From: Simon Davis
Sent: 09 April 2019 12:34
To: Planning.Responses
Subject: FW: Planning Consultation on AL/20/19/DOC
Attachments: BG-8-03-SITE LAYOUT-N - 004.pdf

From: Sue Howell
Sent: 06 March 2019 10:16
To: Planning.Responses [REDACTED]
Cc: Simon Davis [REDACTED]
Subject: RE: Planning Consultation on AL/20/19/DOC

Comment from Greenspace

The information supplied in Dwg BG.8.03.M sets out the planting for the site, but it is a little unclear which is existing and which is the new proposed planting as part of this application.

BOGNOR
BG.8.03.M

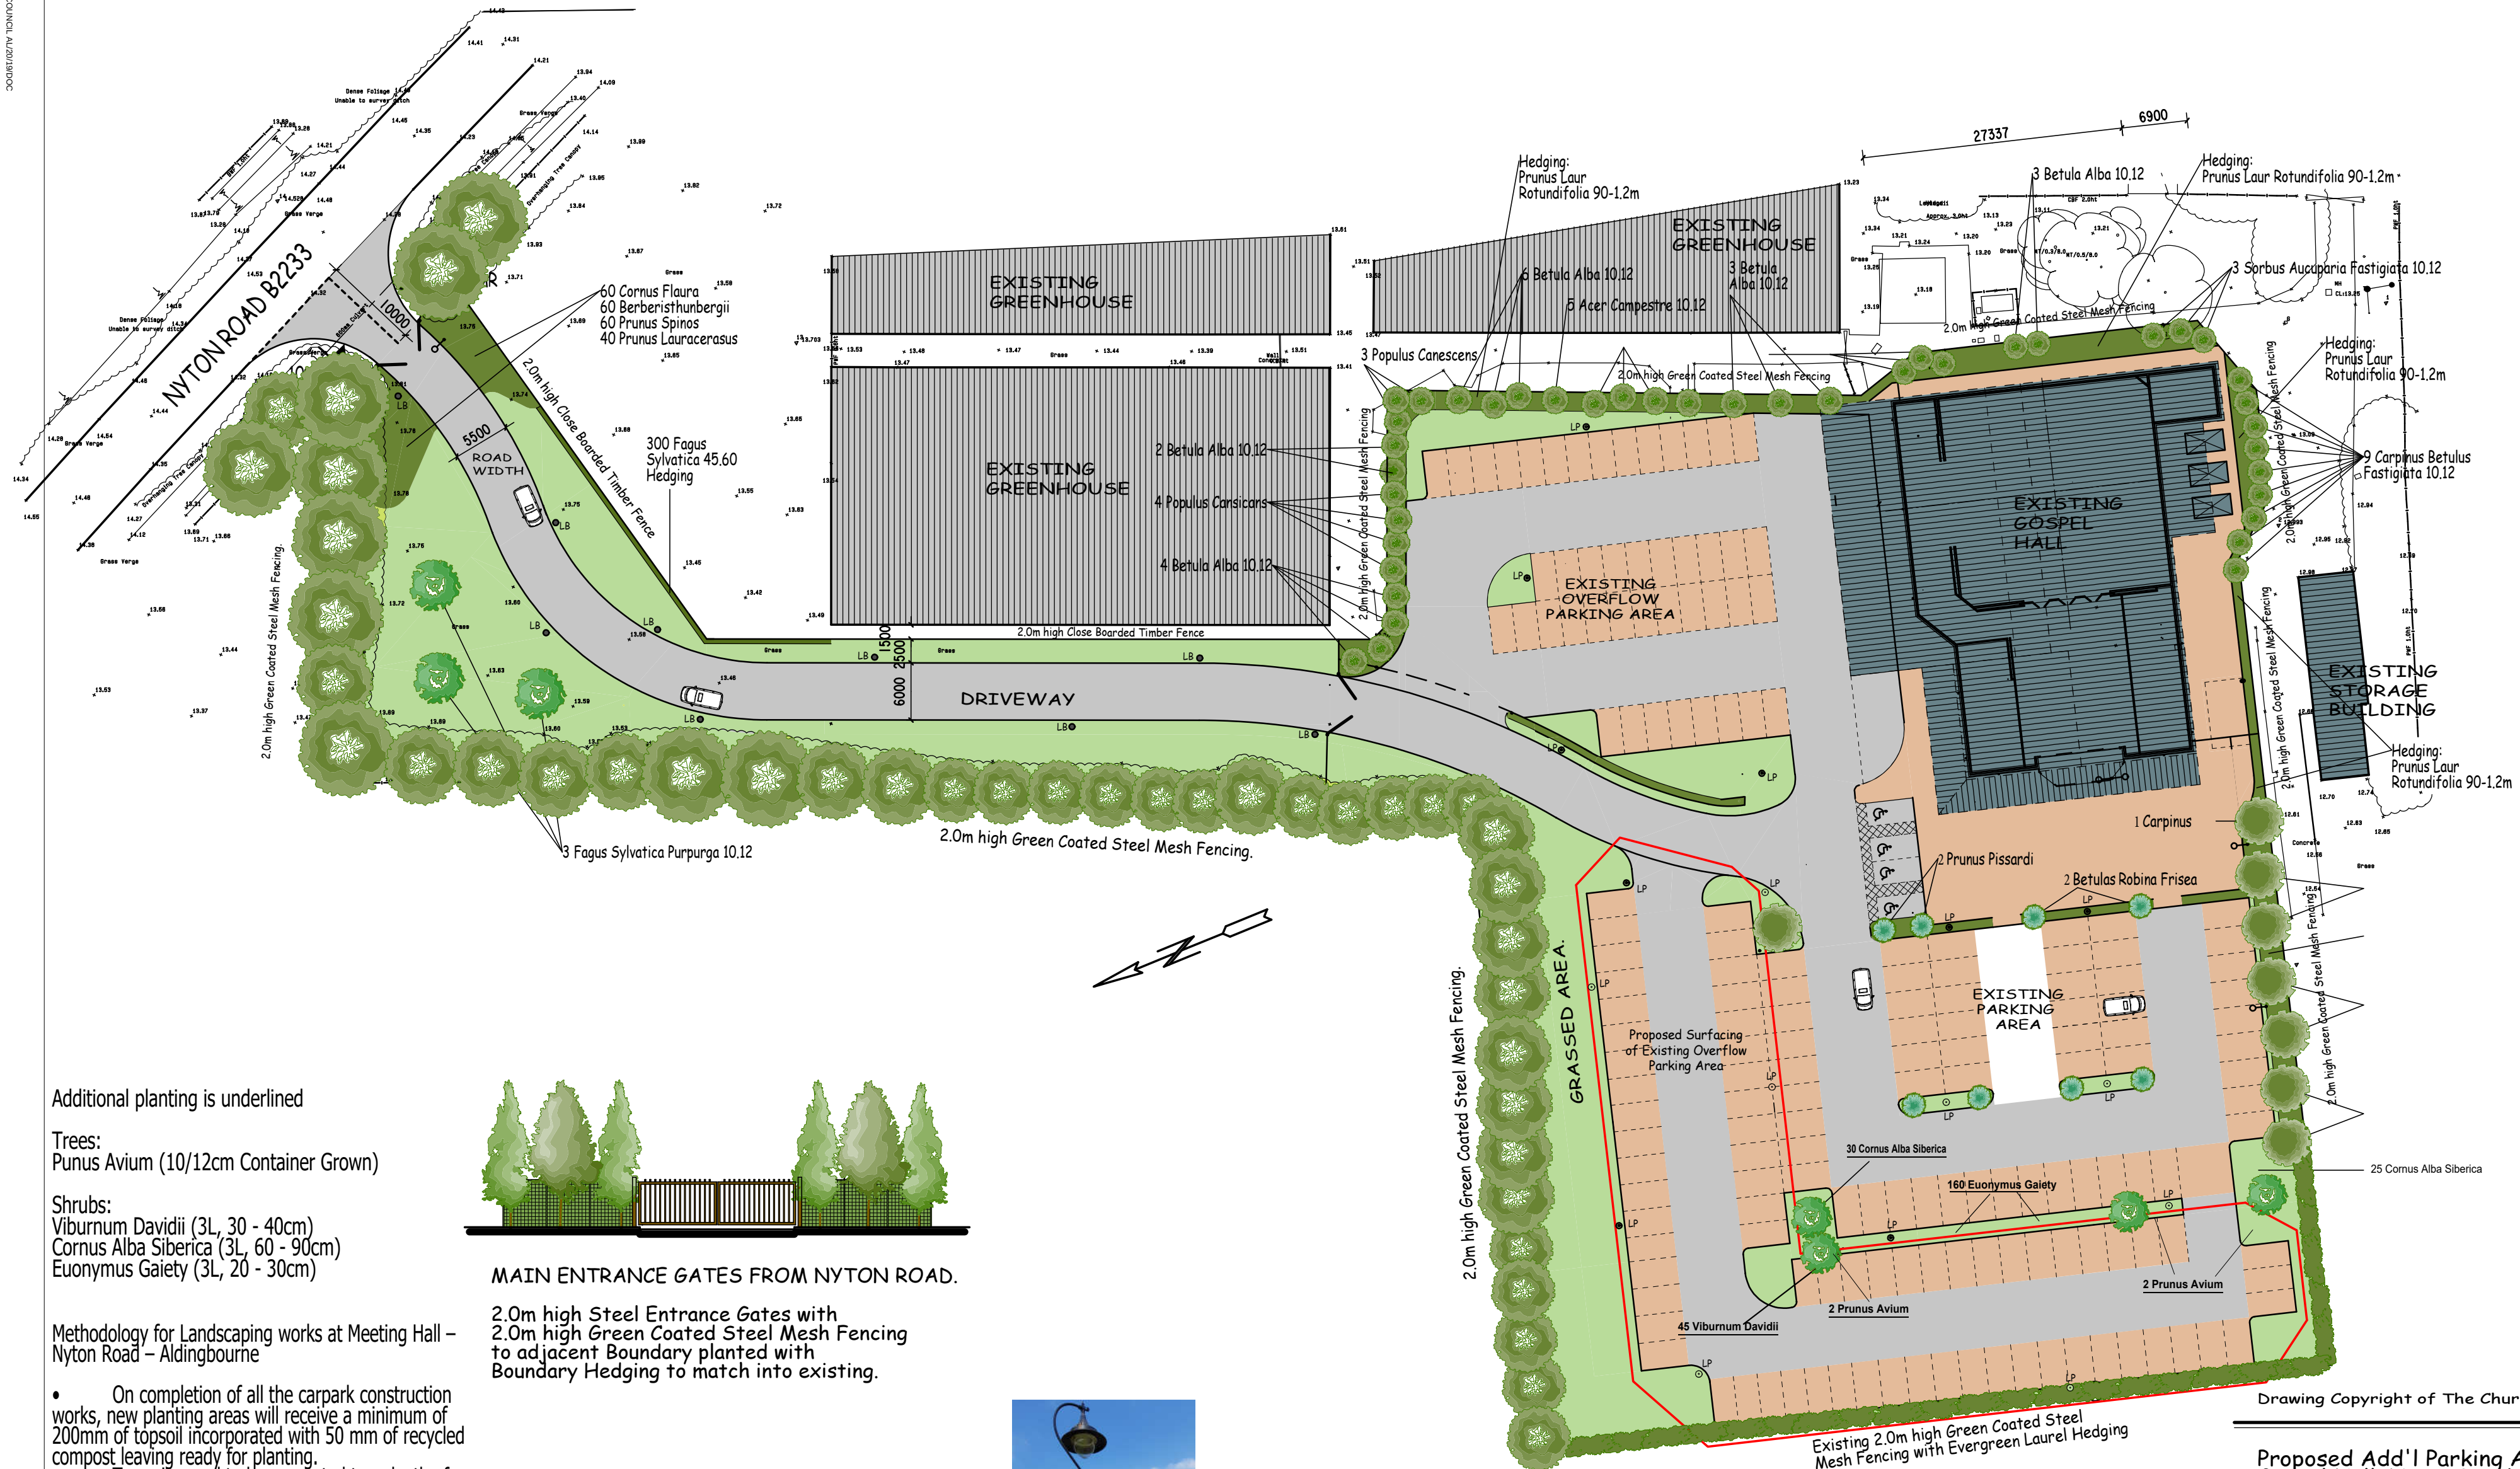
I would recommend that further detail is provided to highlight which is the new planting with a detailed schedule also of quantities, species choice and size at time of planting.

I would recommend that this information is submitted for approval before Condition 4 on AL/20/19/DOC could be considered for discharge.
